The Woodland Trust
Kempton Way
Grantham
Lincolnshire
NG31 6LL

15th February 2022

Reference: A47 Wansford to Sutton Written Representation

Appendix 2: Arboricultural Impact Assessment Plan

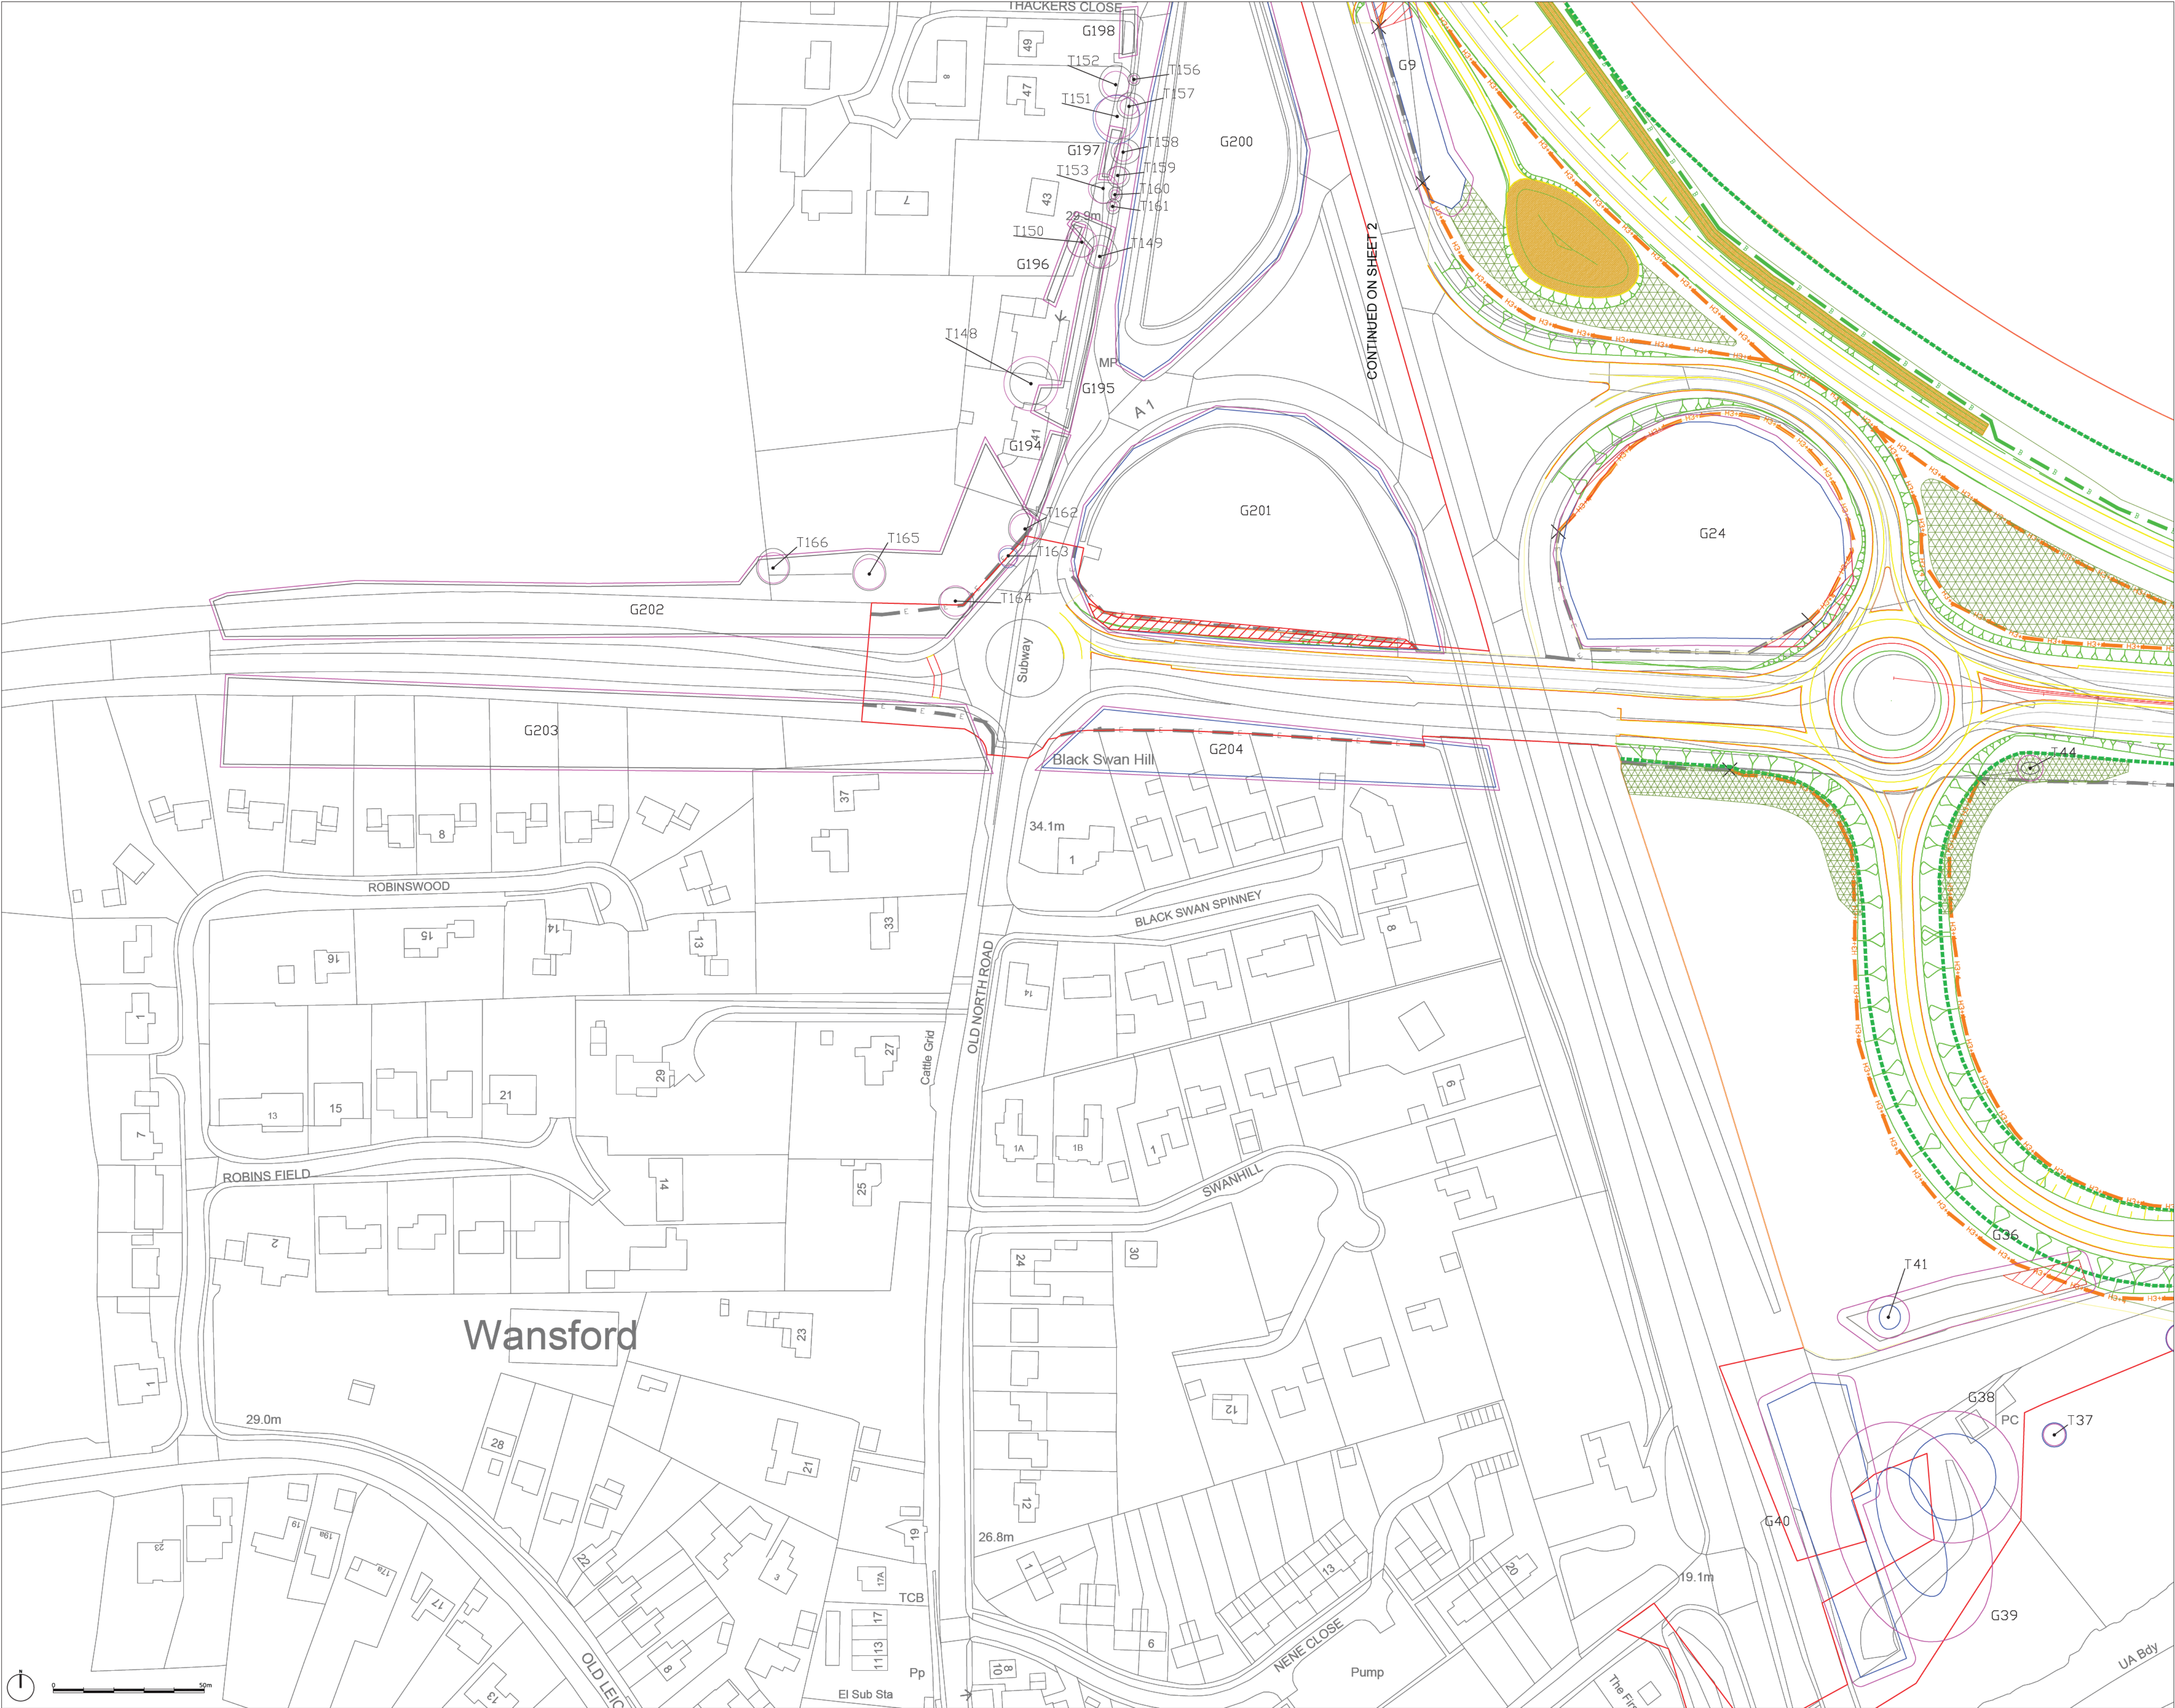
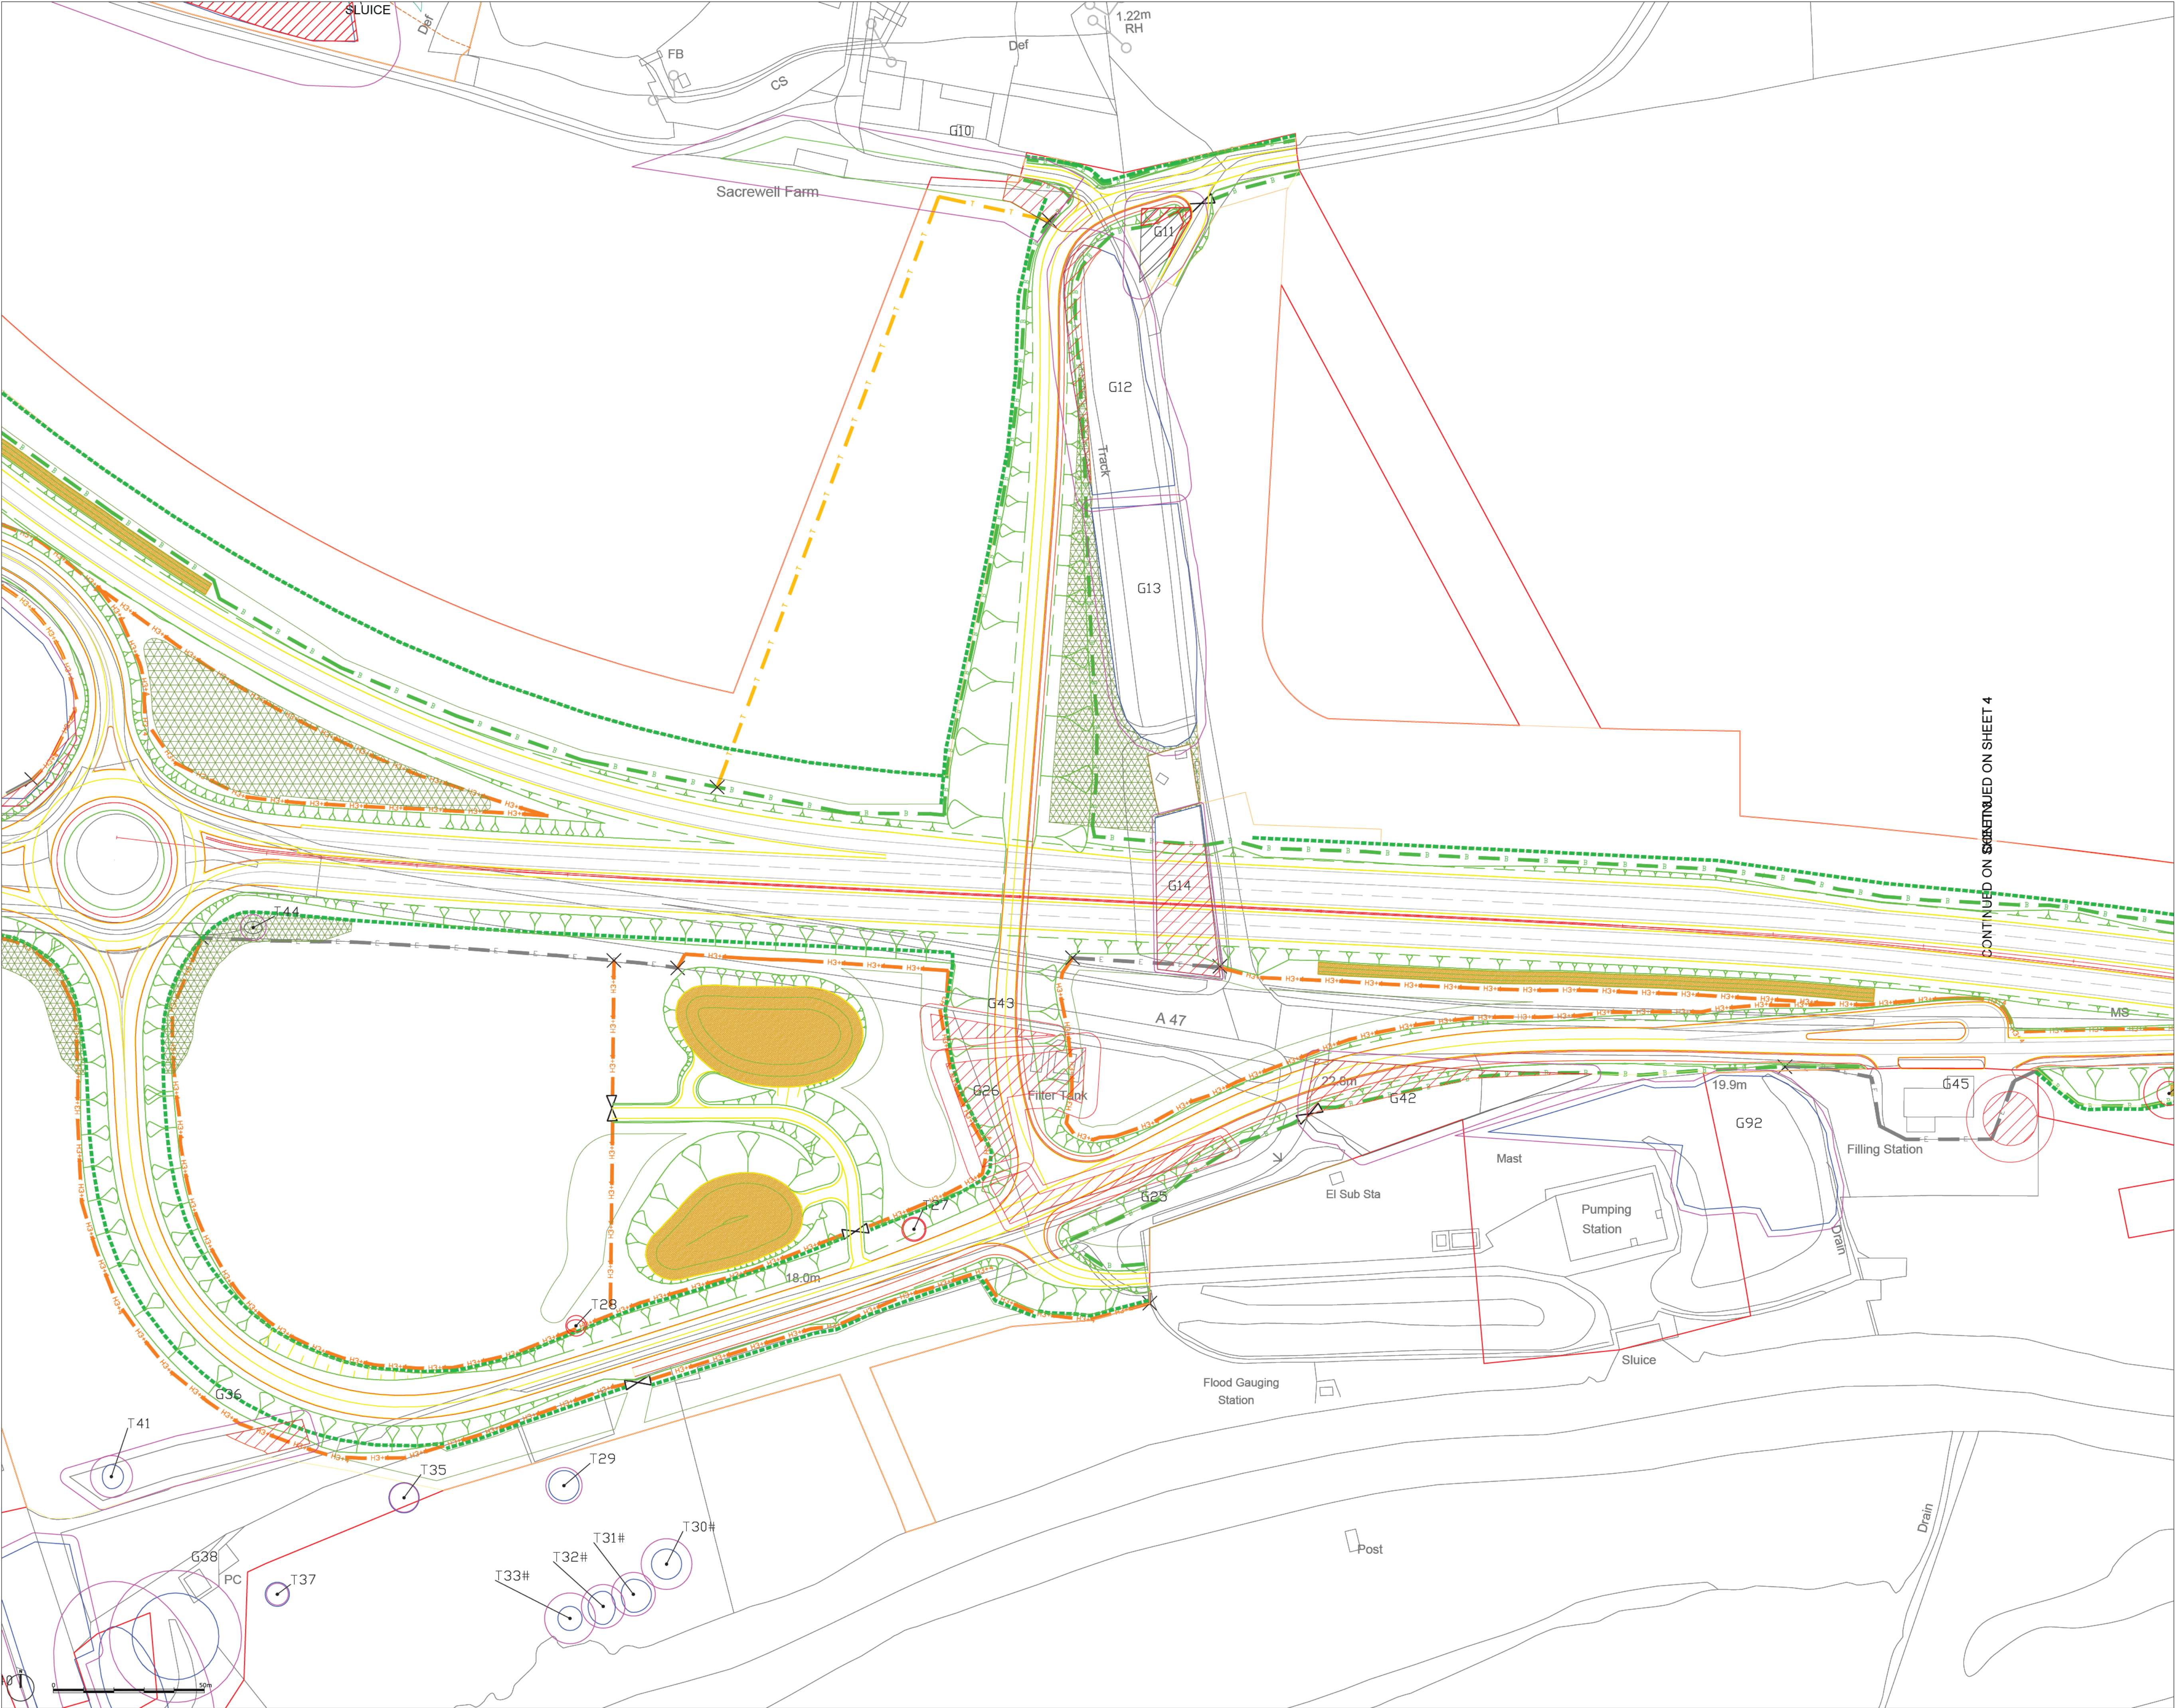
The proposed scheme will result in the loss of a veteran oak tree recorded as T20 within the Arboricultural Impact Assessment report [APP-096]. Therefore, the Trust would like to lodge **an objection** to this development.

The following scheme will result in the direct loss of a veteran oak tree (T20) to facilitate the new carriageway. Natural England’s standing advice for ancient woodland and veteran trees states: *“Direct effects of development can cause the loss or deterioration of ancient woodland or ancient and veteran trees by:*

Natural England’s standing advice for protecting veteran trees is as follows: *“For ancient or veteran trees (including those on the woodland boundary), the buffer zone should be at least 15 times larger than the diameter of the tree. The buffer zone should be 5 metres from the edge of the tree’s canopy if that area is larger than 15 times the tree’s diameter. This will create a minimum root protection area. Where assessment shows other impacts are likely to extend beyond this distance, the proposal is likely to need a larger buffer zone.”* The Trust requests that the applicants retain T20 and provide a suitable buffer zone as befitting a veteran specimen.

In summary, the Woodland Trust requests that veteran tree T20 is retained and afforded a Root Protection Area (RPA) in line with Natural England’s standing advice.
